# THE SHOP'S AT MERIDIAN RANCH

PHOTOMETRIC PLAN

**Shop's @ Meridian Ranch**  
 Site Development Plan  
 Meridian Road  
 Falcon, CO

No. 18,115  
 Date: 6/22/2018  
 Drawing No. **4**  
 PHOTOMETRIC PLAN

DRAWING NO. **4**  
PHOTOMETRIC PLAN

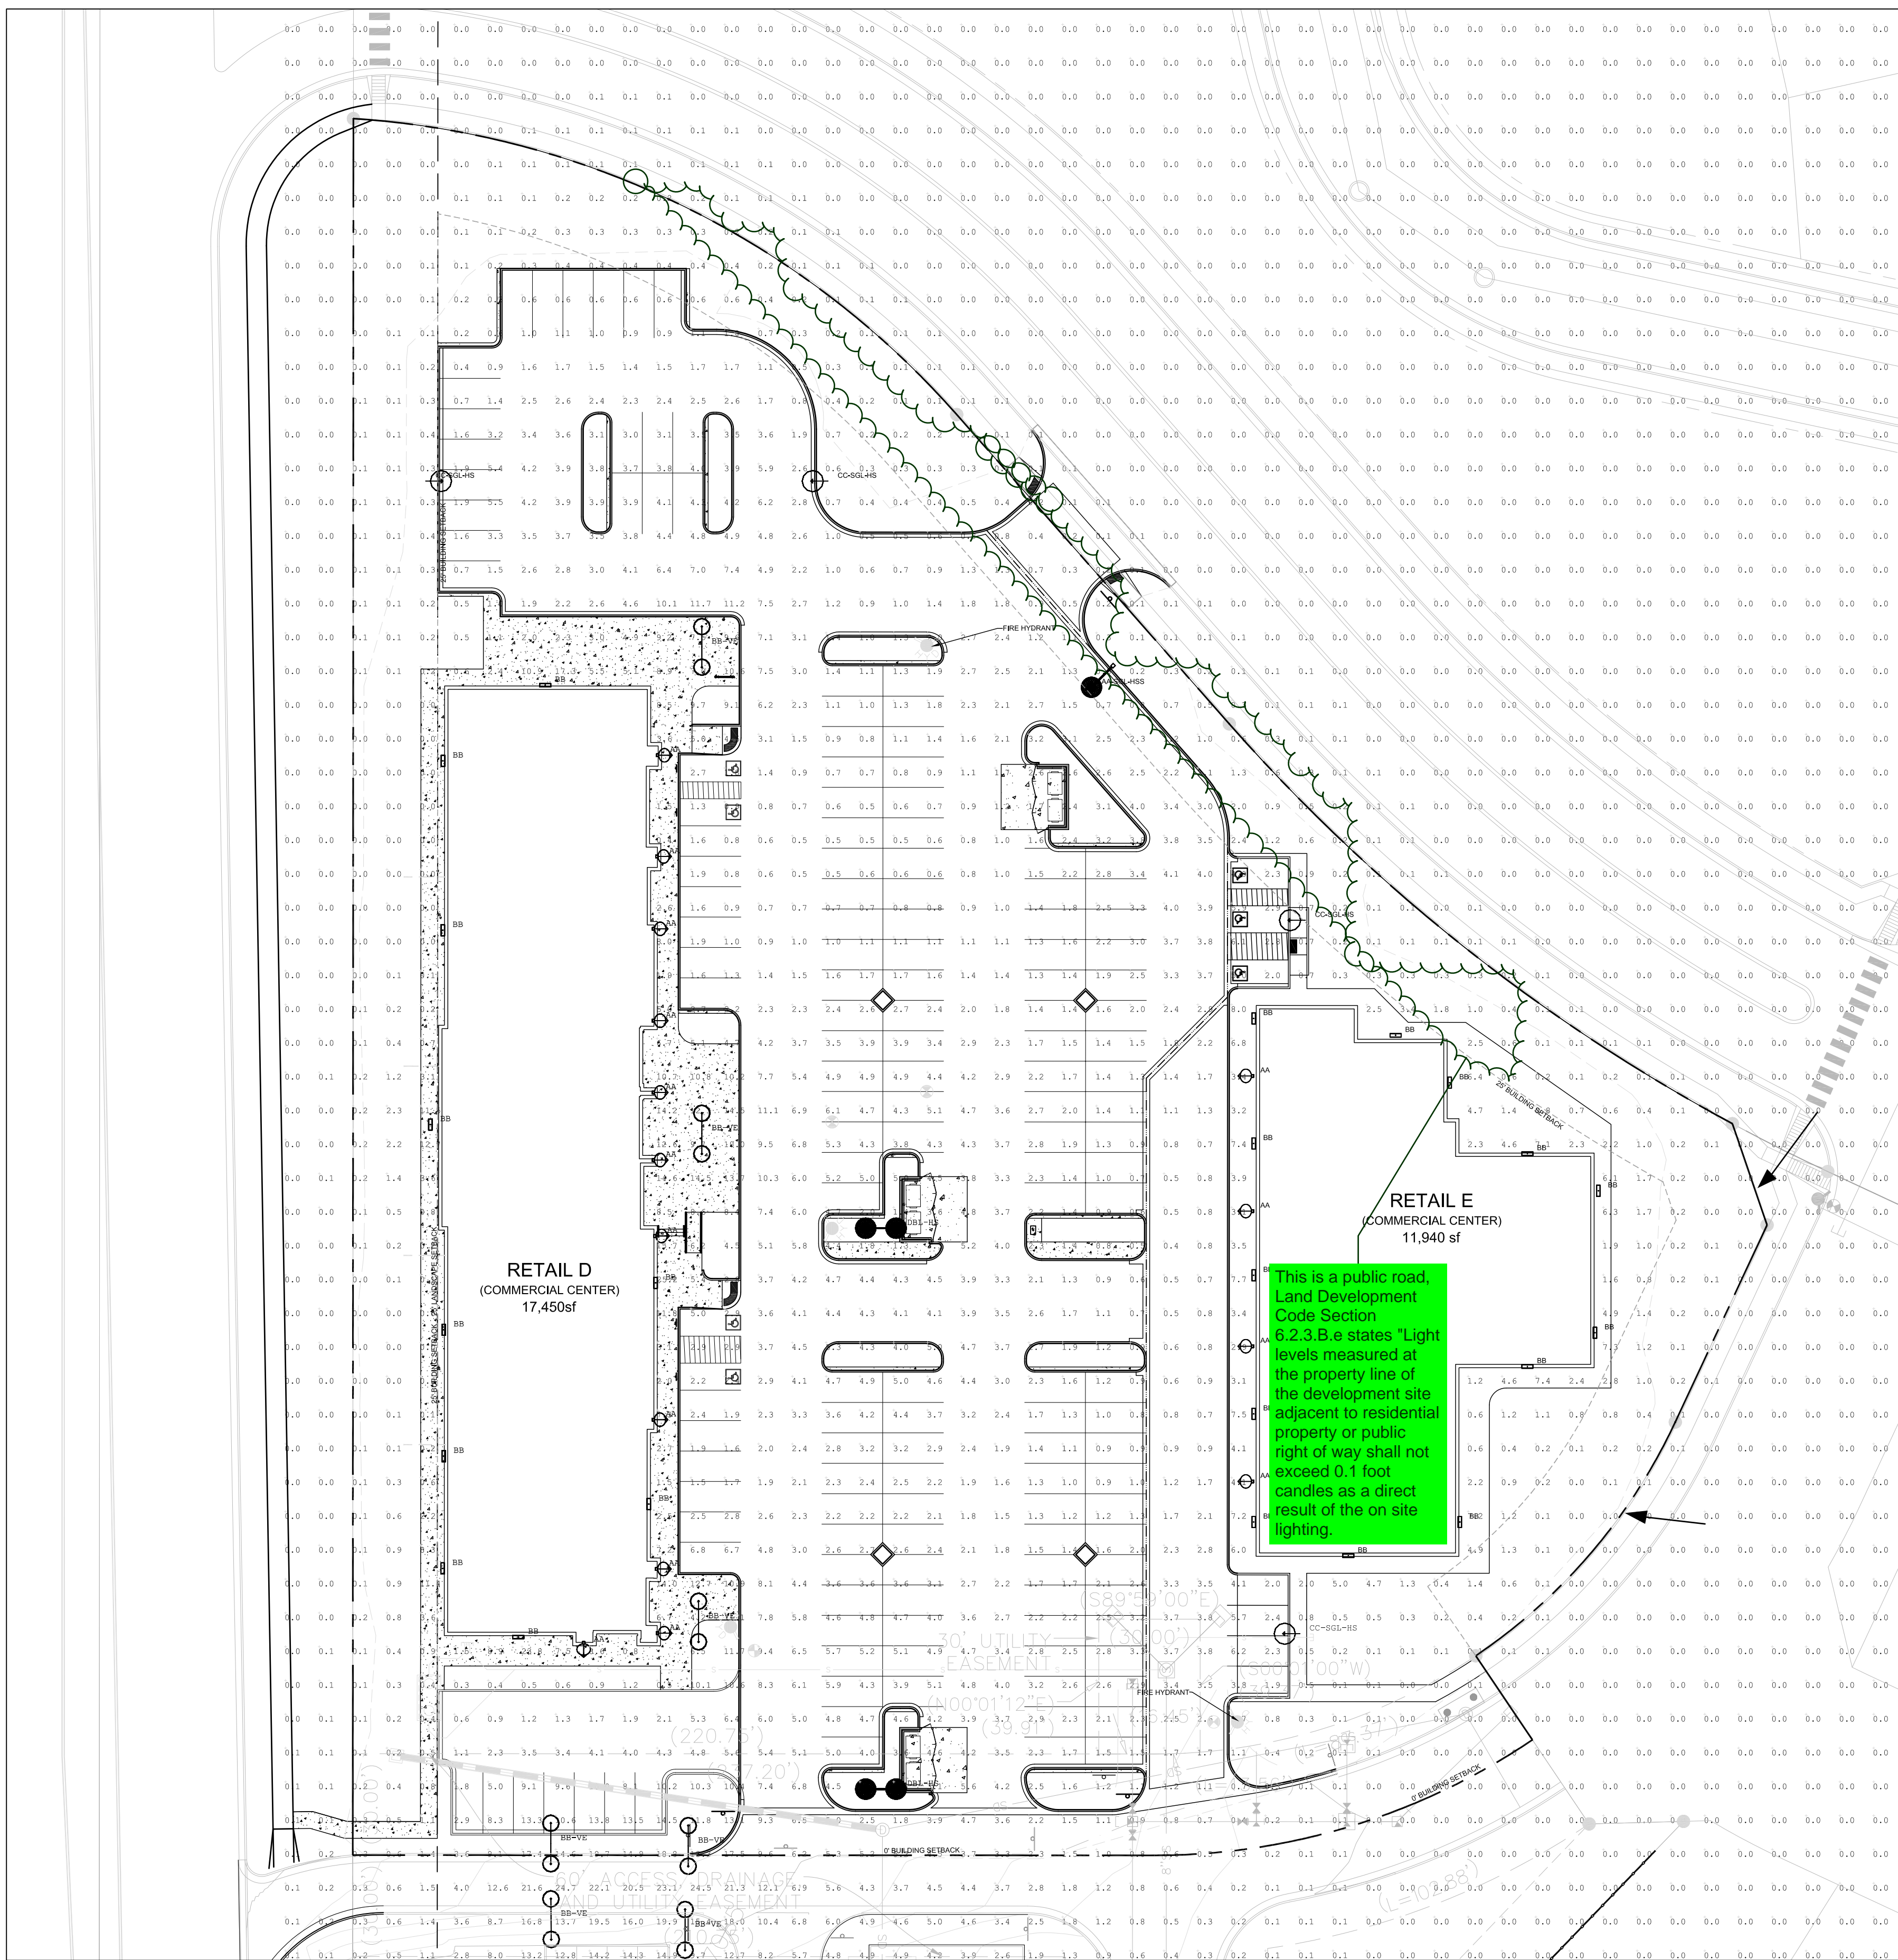
This light cannot exceed 0.1 foot candles adjacent to a public right of way.

Show entire parcel.
